**From:** [Anthony Boscolo](#)  
**To:** [Rachael Stevie \(CD\)](#)  
**Subject:** RU-22-00002 East Peak  
**Date:** Friday, April 22, 2022 4:54:24 PM

Please see my comments below for the project titled RU-22-00002 East Peak:

Exhibit D - Mitigation Plan

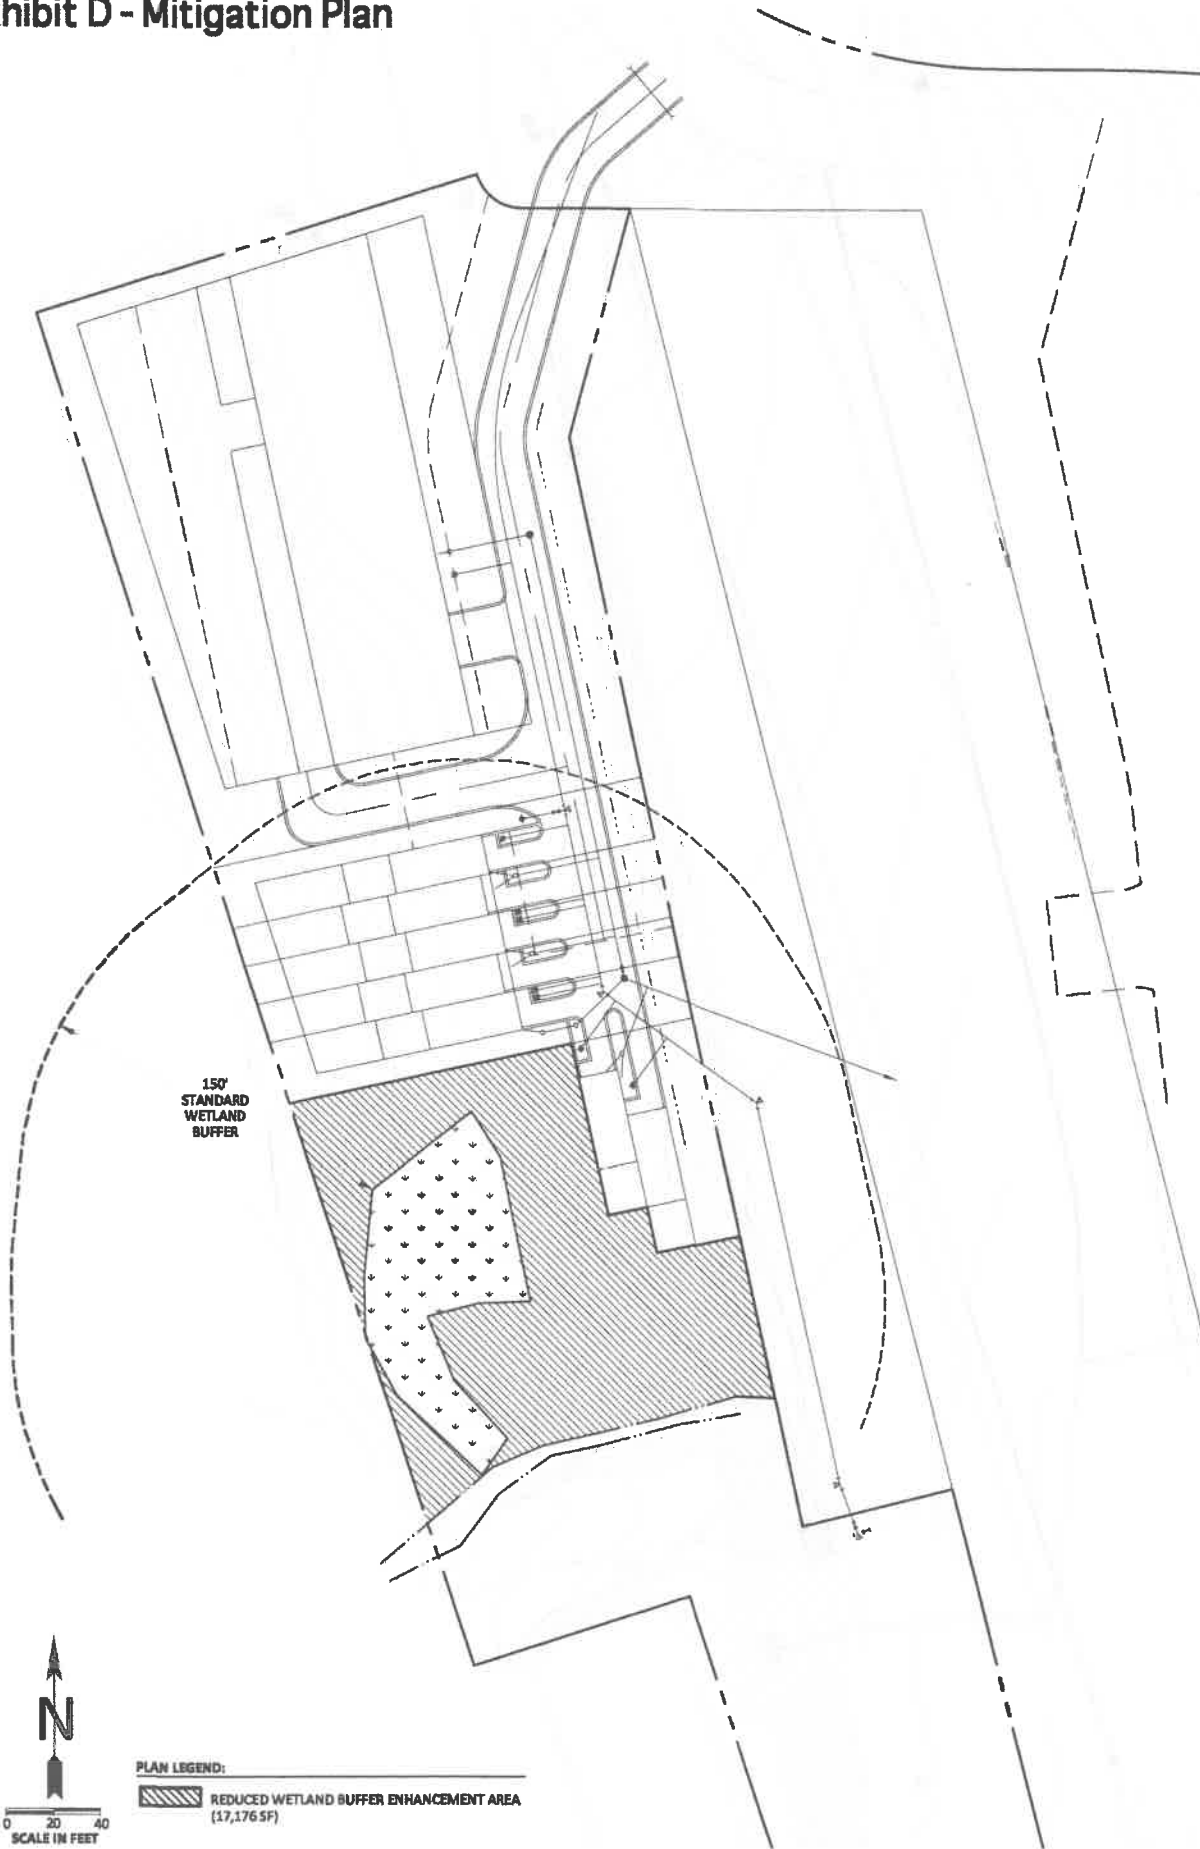
3) Critical Areas Report with Mitigation plan: Again, this report does not cover the entire parcel, thus there is no way to properly review the site for constraints that may warrant a reasonable use exemption. Additionally, The provided report does not contain a mitigation plan, and how they plan to offset their proposed impacts. This is inconsistent with WDOE guidelines for eastern washington.

Exhibit B - PUD Site Plan

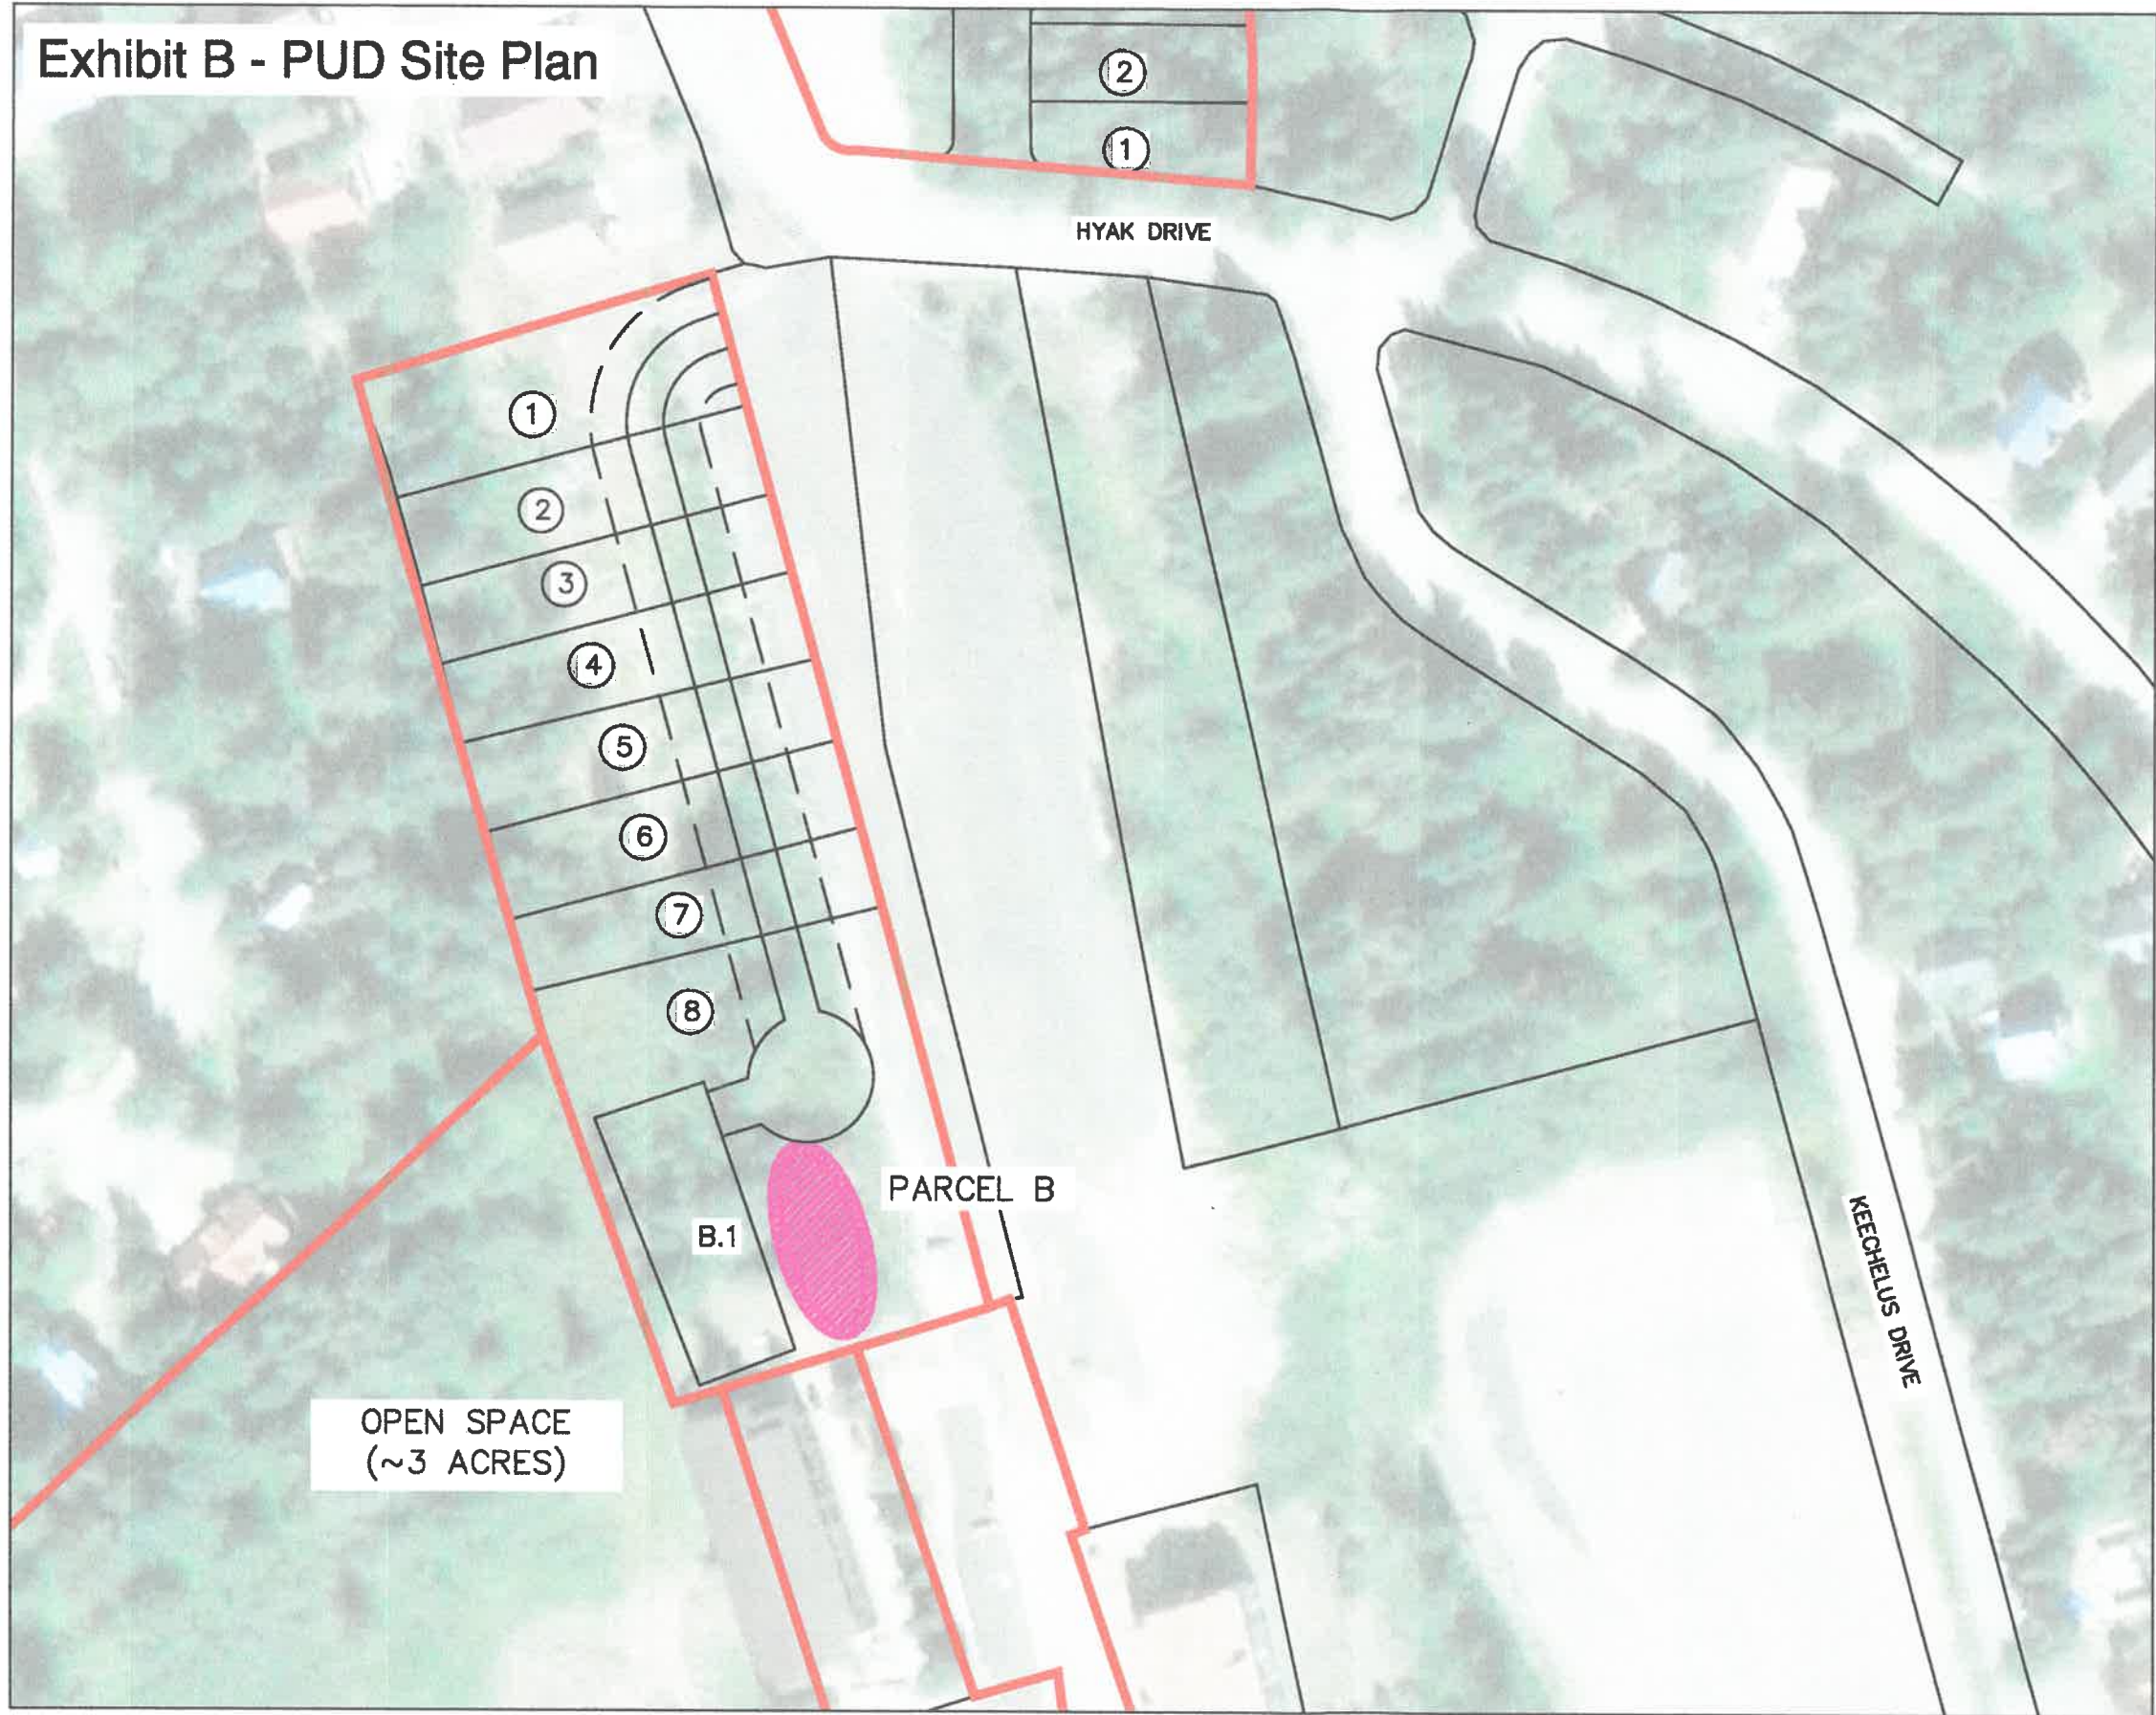
**(The applicant only points to the 2018 PUD as a baseline for this density and use. But that PUD was approved without an accurate wetlands / Critical areas report being completed. This is not the fault of the zoning map, but rather the proper analysis during the development of the PUD. One of the main reasons to go through the PUD process to shape the PUD around features such wetlands and their buffers. It is very apparent (because of the submittal of this RU variance request) that during the establishment of the PUD, there was a lack of accurate environmental information, which puts into question the contents of the PUD. Further, the analysis does not demonstrate anything less than complete buildout. The wetland and its buffer only incomber a fraction of the apx 27 acres of the subject parcel. )**

**(In the proposed PUD (in its entirety, not just the subset referenced in this limited variance request) there are a number of different use types, Residential, commercial, open space, etc. The applicant has only shown us what placing varying densities of residential use in the subject area, they have not analysed the other approved uses within PUD, and what their impact would be given the buffer and setback constraints. )**

EXHIBIT A - PROPOSED SITE PLAN

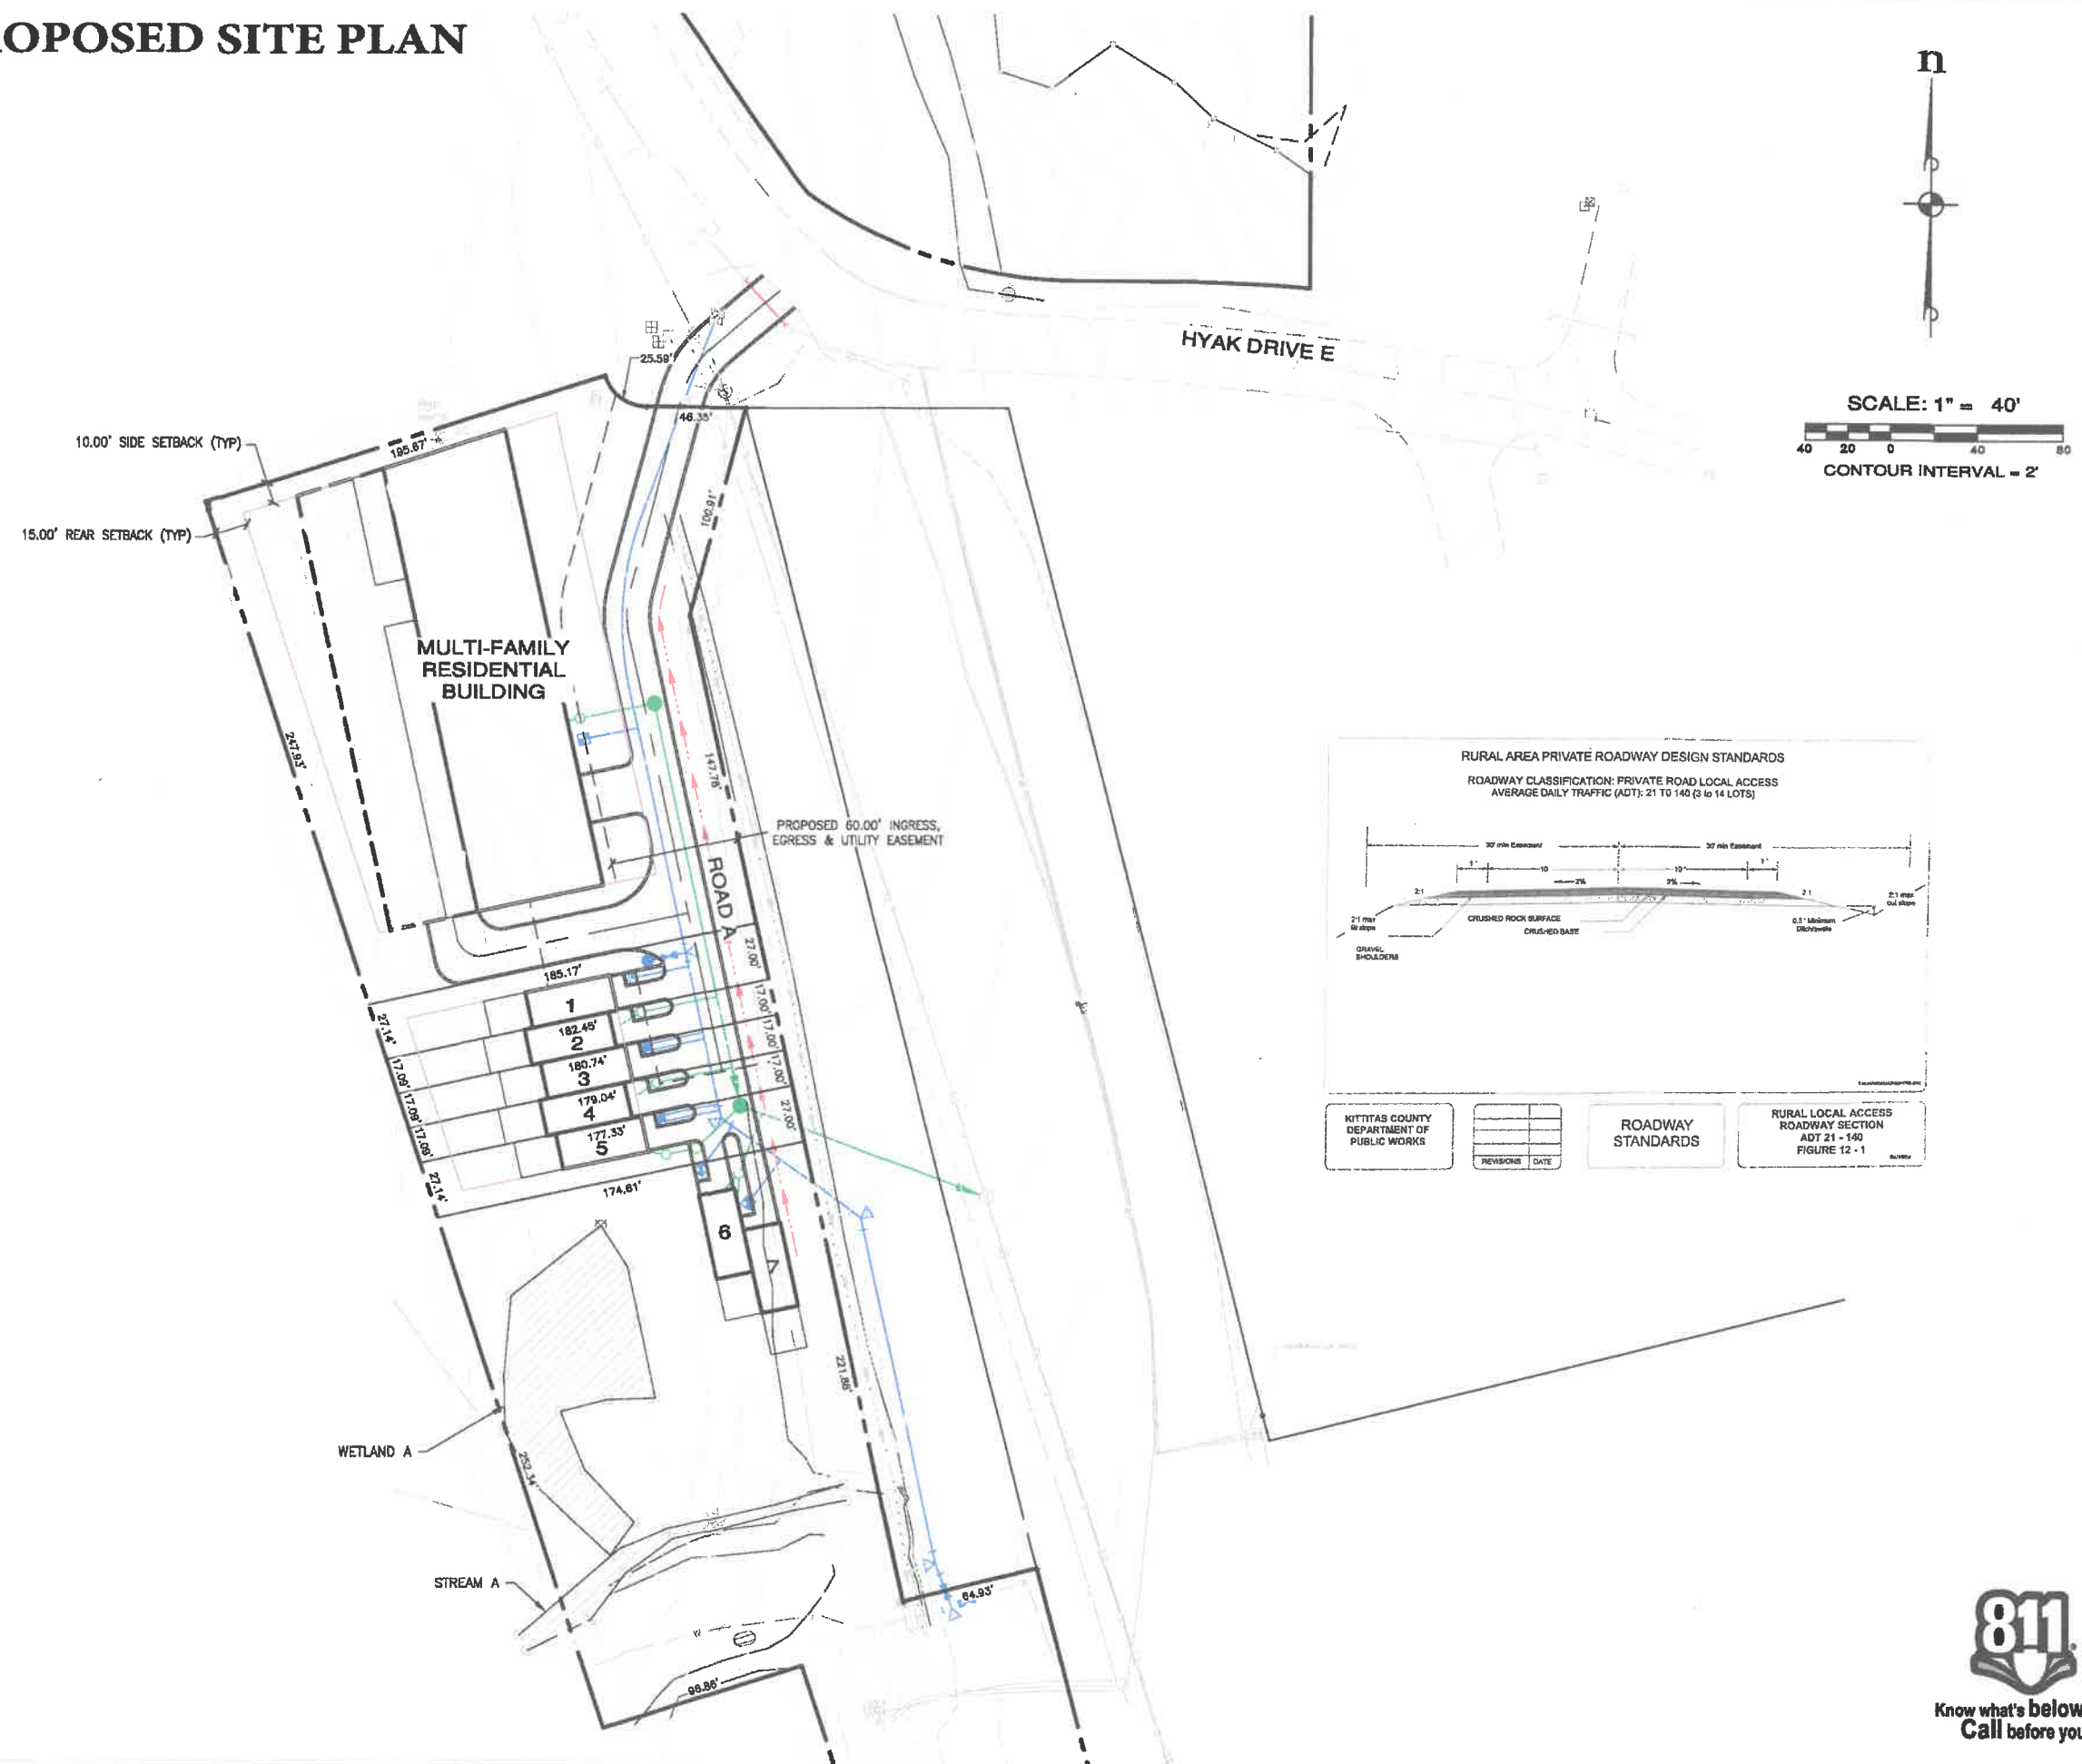
1) Site Plan: This application is not complete, and should not have been accepted. It does not contain a complete site plan. It is missing many of the key elements which are essential for proper review. It does not contain the complete parcel, and it doesn't contain all proposed structures, drainage, wetlands, etc. There are approximately 25 acres of the subject parcel which have been ignored in this application. In order to properly review this application, we need the whole picture.

**(As stated before, one can not determine if this is the minimum necessary, as the subject parcel has 23 acres not being shown or analysed in this application. If the remainder of the parcel was entirely encumbered by wetlands and their buffers, then the applicant's request may actually be the minimum necessary, but since we have not been given the full picture, there is no way to tell. We need a detailed critical areas report for the entire parcel / PUD, with all proposed developments in order to determine if this reasonable use variance should be granted. )**

**(Prior to the effective date of this Title, the applicant did perform a short plat on the property. In doing so, they created a single apx. 27 acre parcel. That parcel in its entirety needs to be in this application in order to review it for reasonable use, not just this small subset call tract b. The reasonable use section of KCC has no reference to Tracts, only parcels. )**
